Our Case Number: ACP-324568-26

Re: Proposed Development of the Barnesmore Gap Greenway Project
County Donegal

**Letter of Observation / Submission to An Bord Pleanála
Barnesmore Greenway Application and CPO**

Case Number: ACP-324568 Date: 30 September 2026

© Copyright Acknowledgements Includes Ordnance Survey Ireland data reproduced under OSI Licence Number 2023/OSI NMA 053. Reproduction infringes Ordnance Survey Ireland and Government of Ireland Copyright.

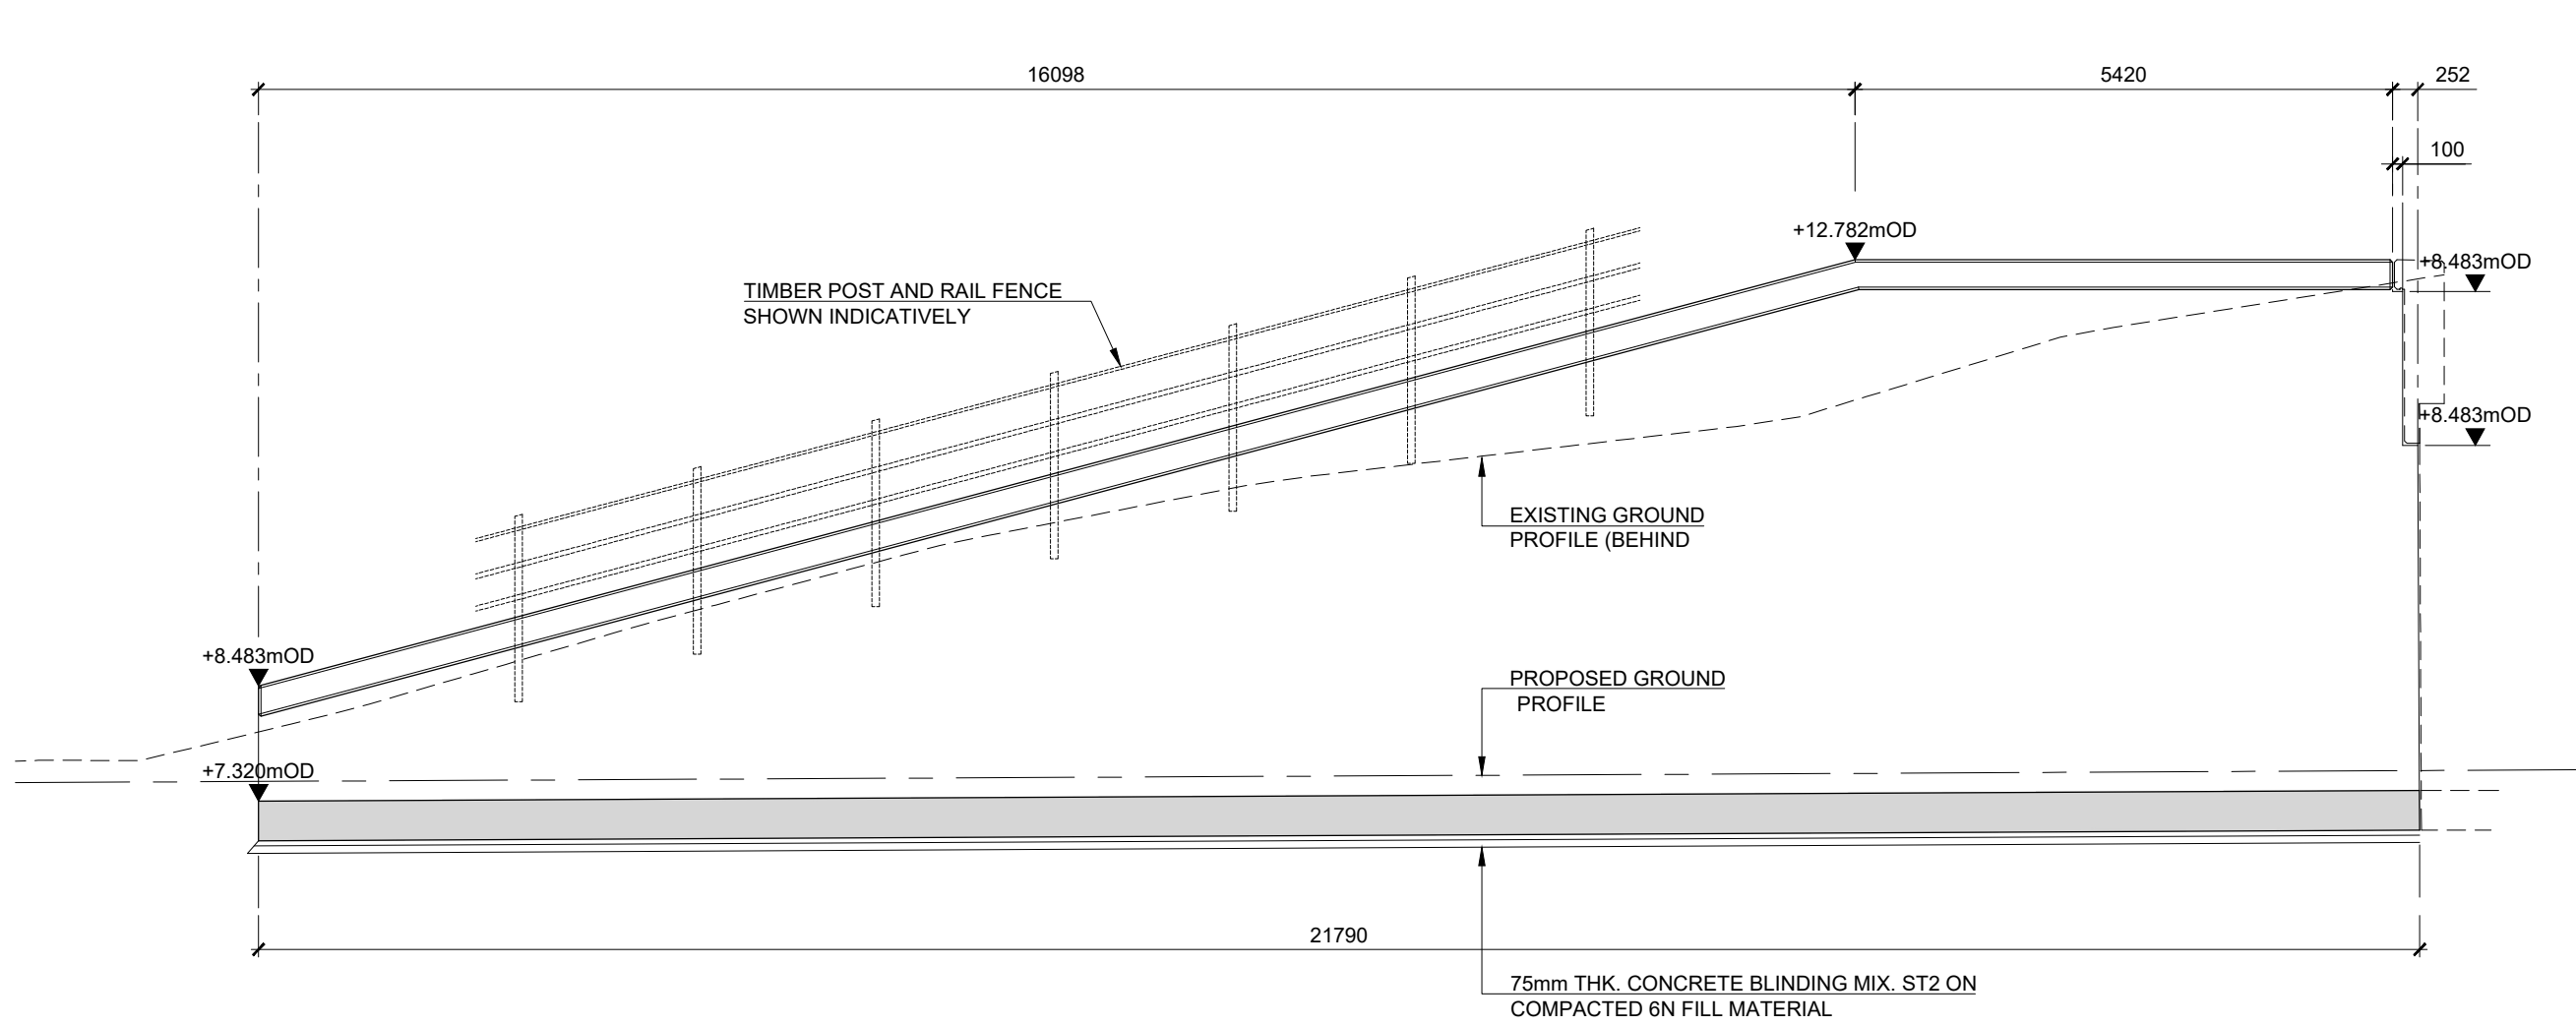
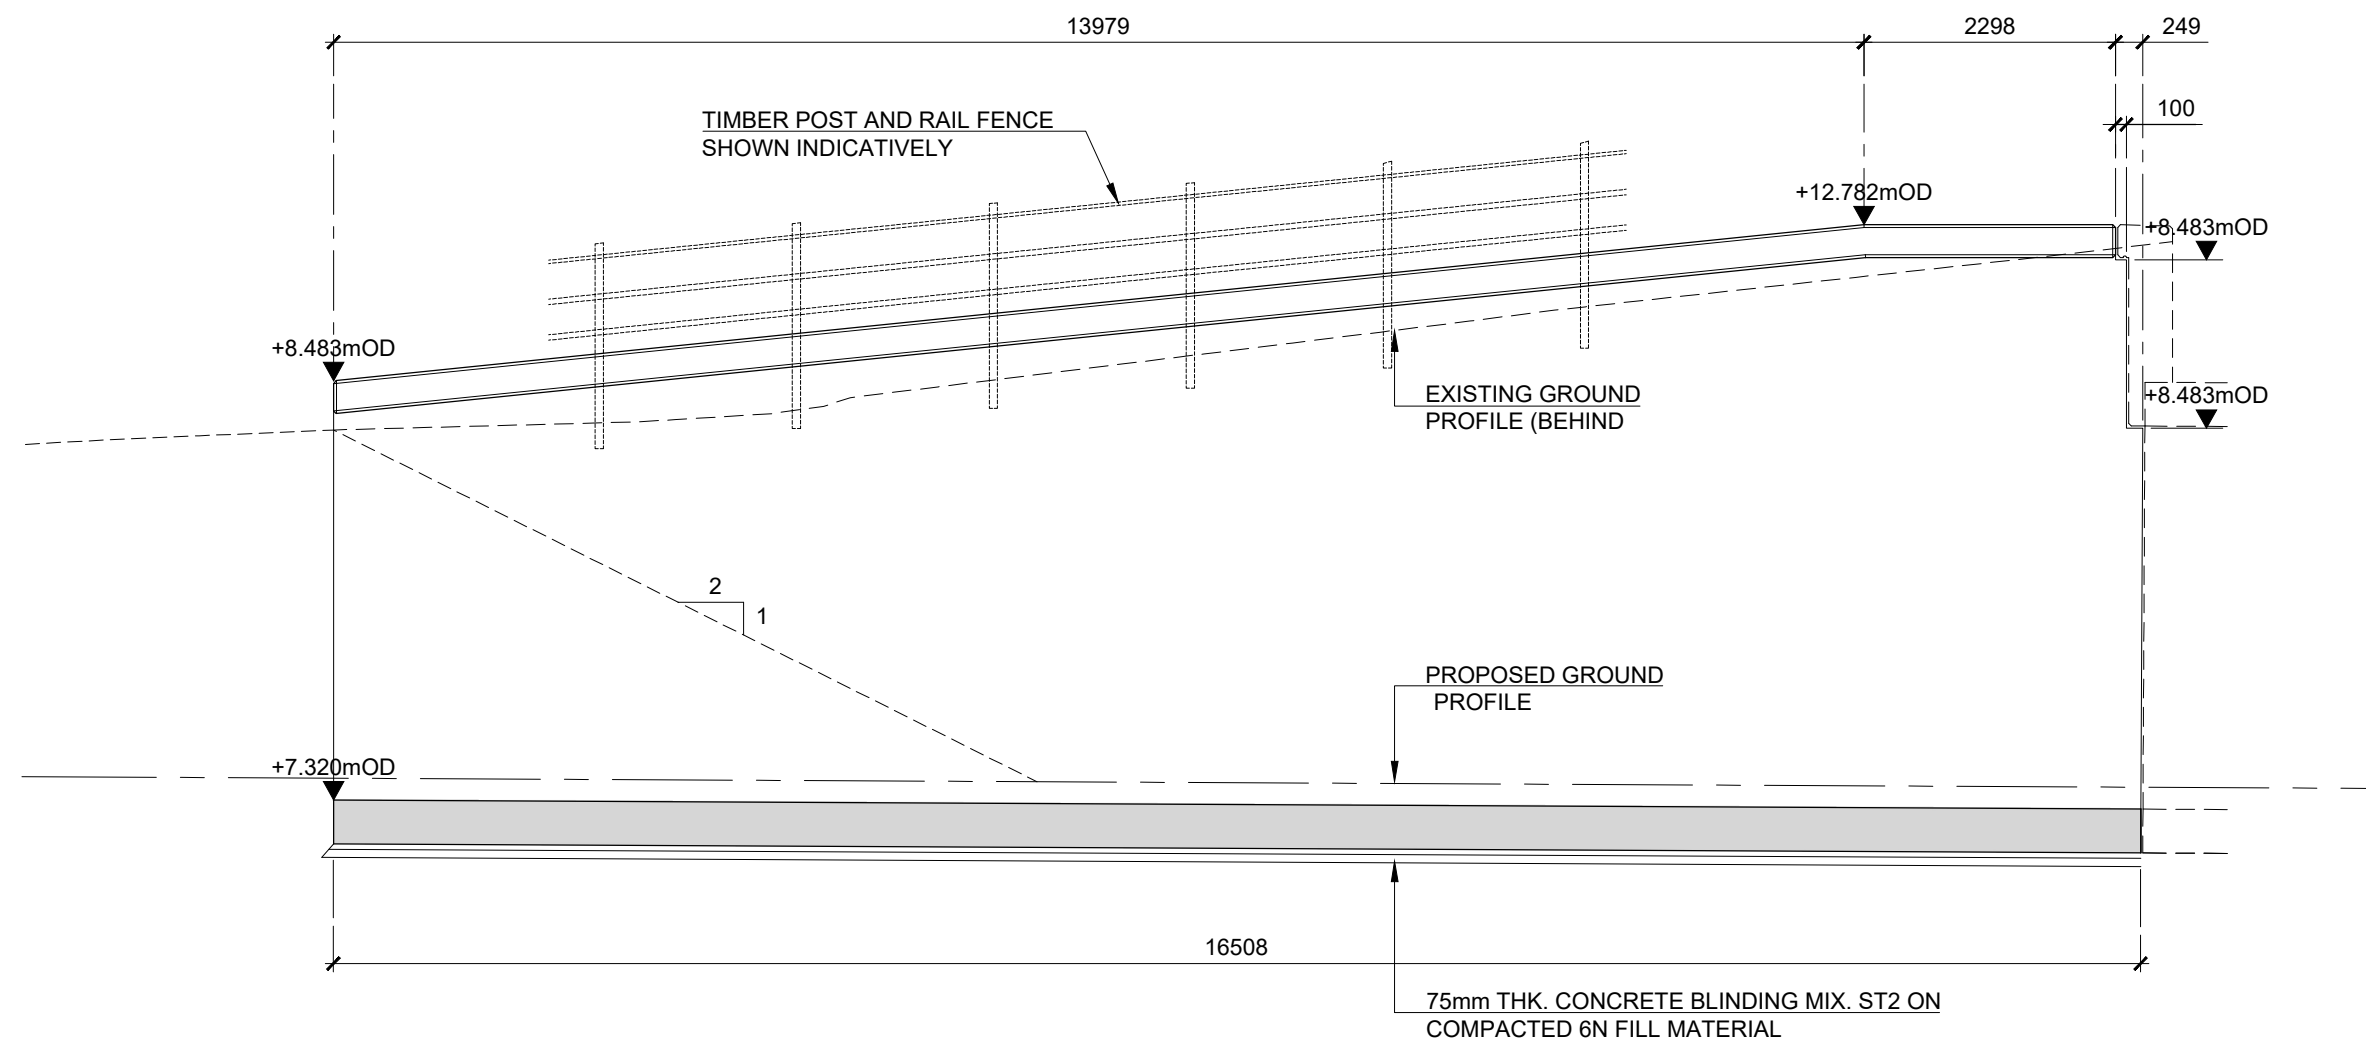
2. Location of the Greenway and Underpass S02

The location of the S02 underpass and associated greenway corridor across my late father's landholding has already been fixed as part of the Phase 2 design submitted to An Bord Pleanála. The EIAR treats both the underpass and the greenway alignment as established, engineered elements of the scheme, with their siting, gradients, land-take and structural tie-ins fully assessed and locked into the statutory environmental documentation.

The proposed underpass will physically separate the land from adjoining lands zoned as an Opportunity Area. This represents a material and permanent change to the structure of the landholding. The separation will significantly reduce the functional relationship between the parcels and diminish the strategic value that originally justified the acquisition of the land.

The footprint of the underpass, approach ramps and drainage basins will materially reduce the usability, coherence and amenity of the remaining lands. This severance will have a lasting impact on the functional and practical use of the property.

The proximity of the underpass to the remainder of the land will result in permanent changes to noise levels, visual outlook, privacy and general amenity. These impacts will endure for the lifetime of the structure and will materially affect the value and enjoyment of the property. These matters will be discussed with the Council in due course.

The proposed works introduce a significant engineering burden, including retaining structures, excavation, embankments and long-term maintenance zones. These elements will permanently alter the character and usability of the land and impose constraints that would not otherwise exist.
